Online Comment

Application H08-1256-21
Location Land off York Gardens Gosberton Spalding PE11 4HT
Proposal Proposed residential development of 92 - 1, 2, 3 and 4 bedroom dwellings with public open space, pedestrian link to Low Gate Medical Centre and access from York Gardens.

Name Sue Armour - Environmental Protection Officer
Address South Holland District Council Priory Road Spalding PE11 2XE

Date Submitted 13-12-22
For/Against Comments

Site Investigation Plan

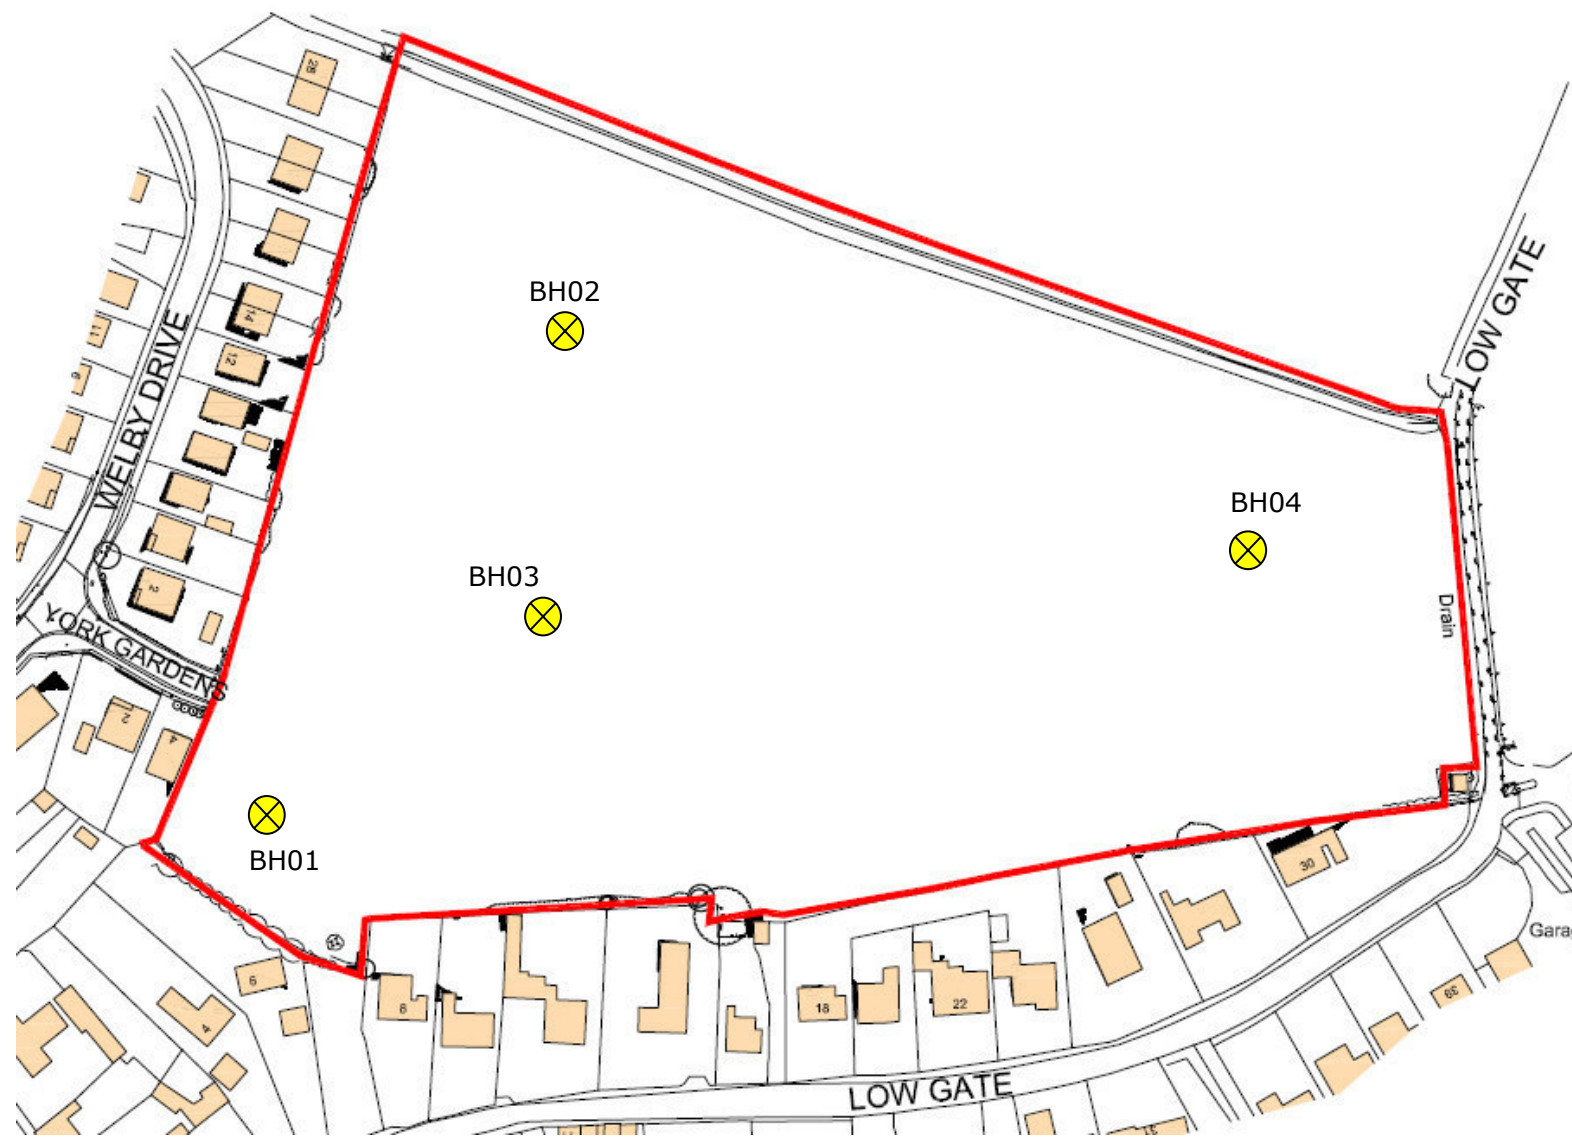
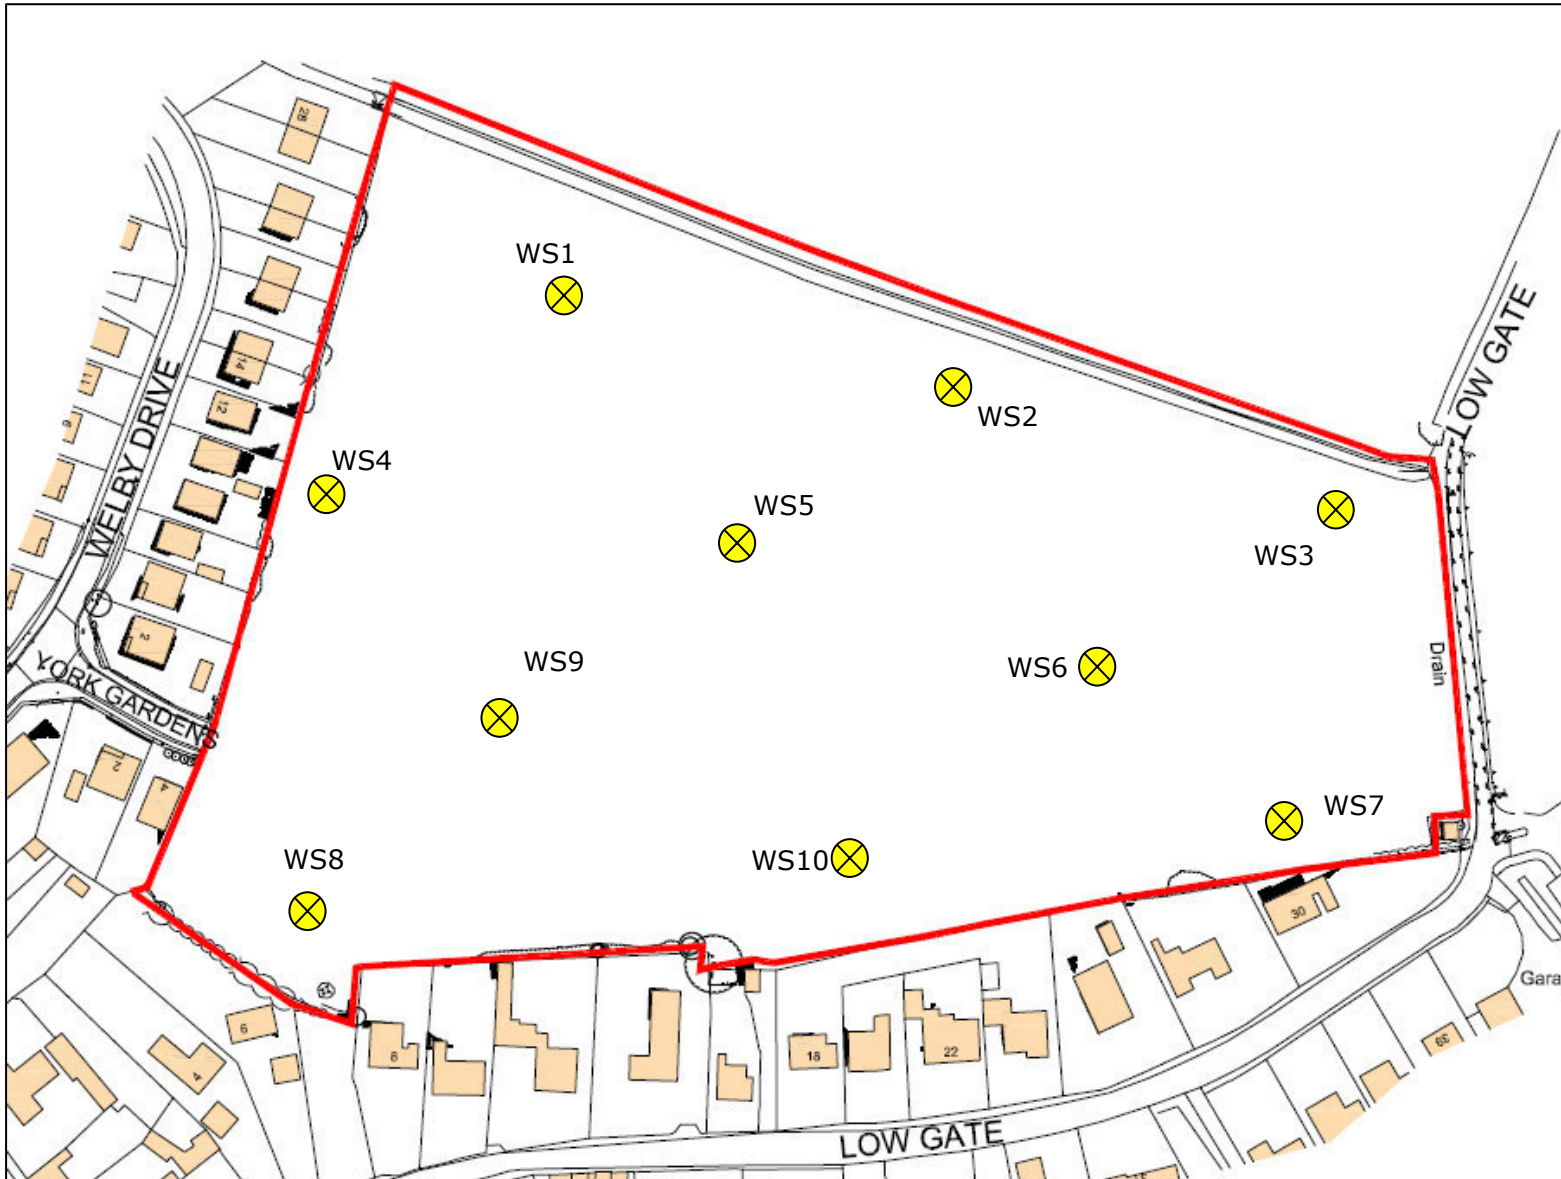
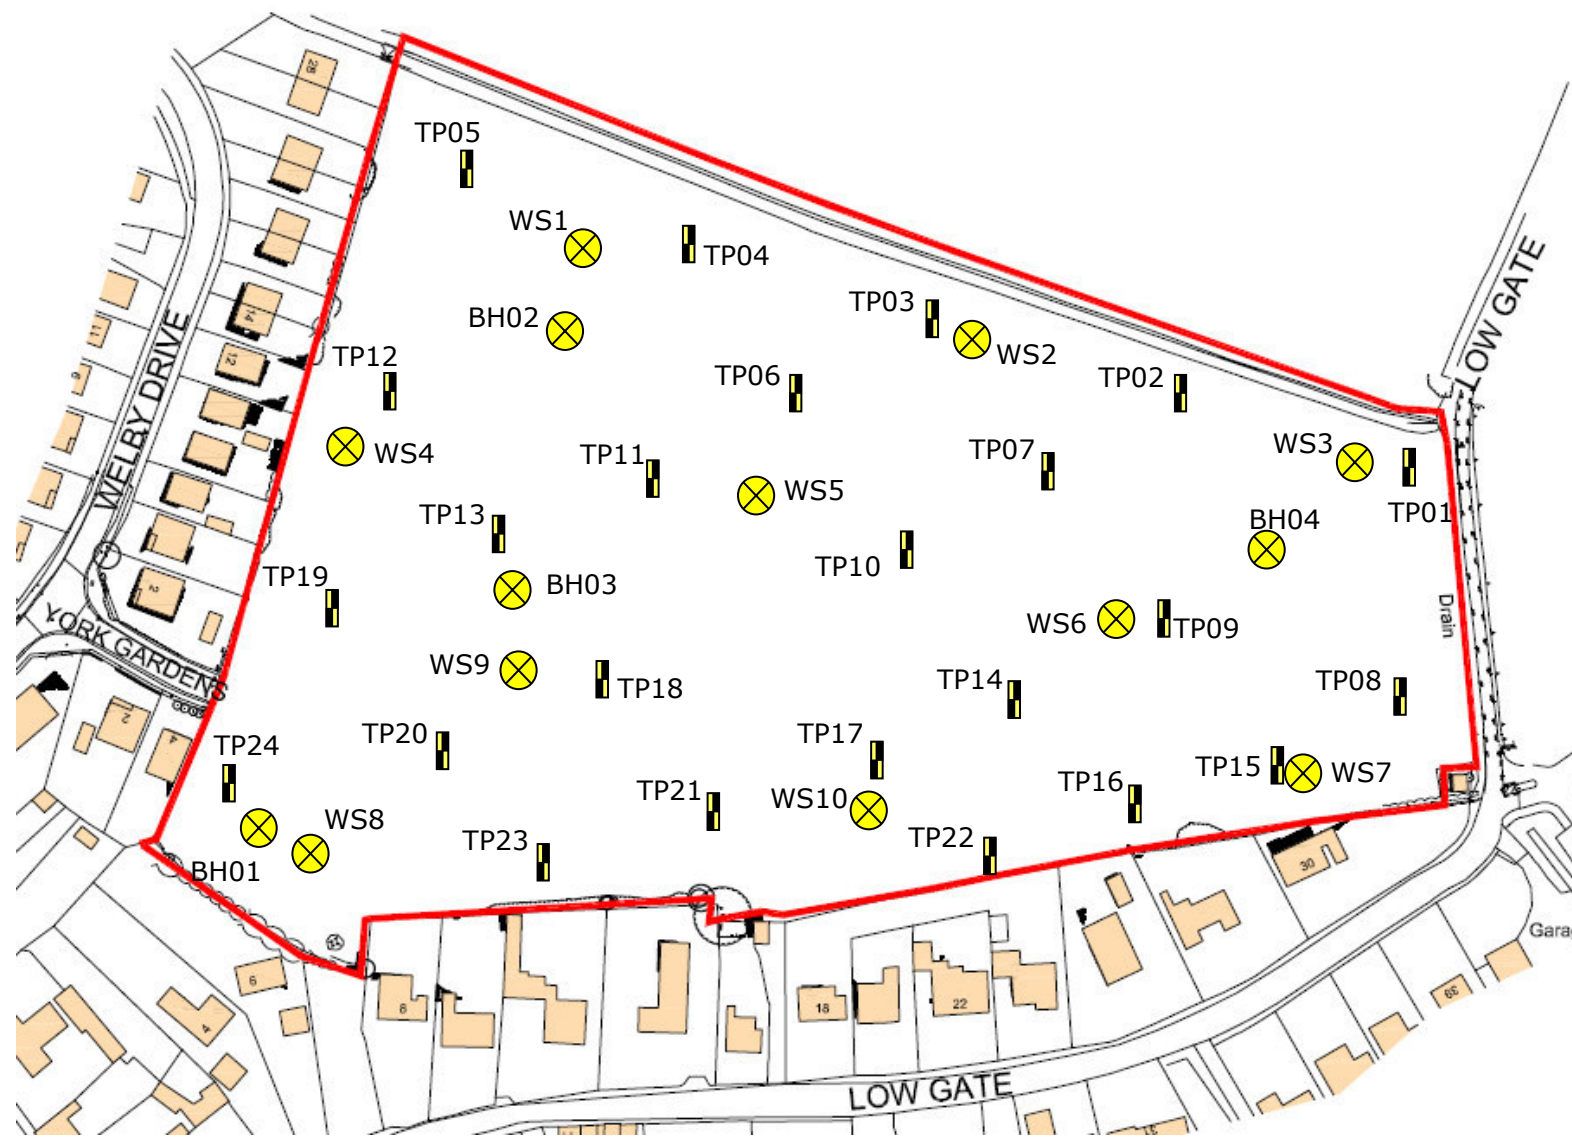
I am concerned that the proposed remediation of 1msquare is both unpractical and ineffective - there is nothing in the site investigation report that would suggest that the petroleum hydrocarbons recorded would be limited to such a small area - there's no notable difference in the soil descriptions between TP08 and any other. I would like to see, in a remediation method statement, some further sampling to delineate any area of proposed remediation.

The development hereby permitted shall not be commenced until a scheme to deal with any contamination of land or pollution of controlled waters, has been submitted to and approved in writing by the Local Planning Authority (LPA). The scheme shall include a written method statement detailing the remediation strategy for land contamination and/or pollution of controlled waters affecting the site and a timetable for their completion shall be submitted to and approved in writing by the LPA. This shall include details of the proposed verification plan including compliance criteria and monitoring details. No deviation shall be made from this scheme without the express written agreement of the LPA. If during redevelopment contamination not previously considered is identified, then the LPA shall be notified immediately and no further work shall be carried out until a method statement detailing a scheme for dealing with the suspected contamination has been submitted to and agreed in writing by the LPA.
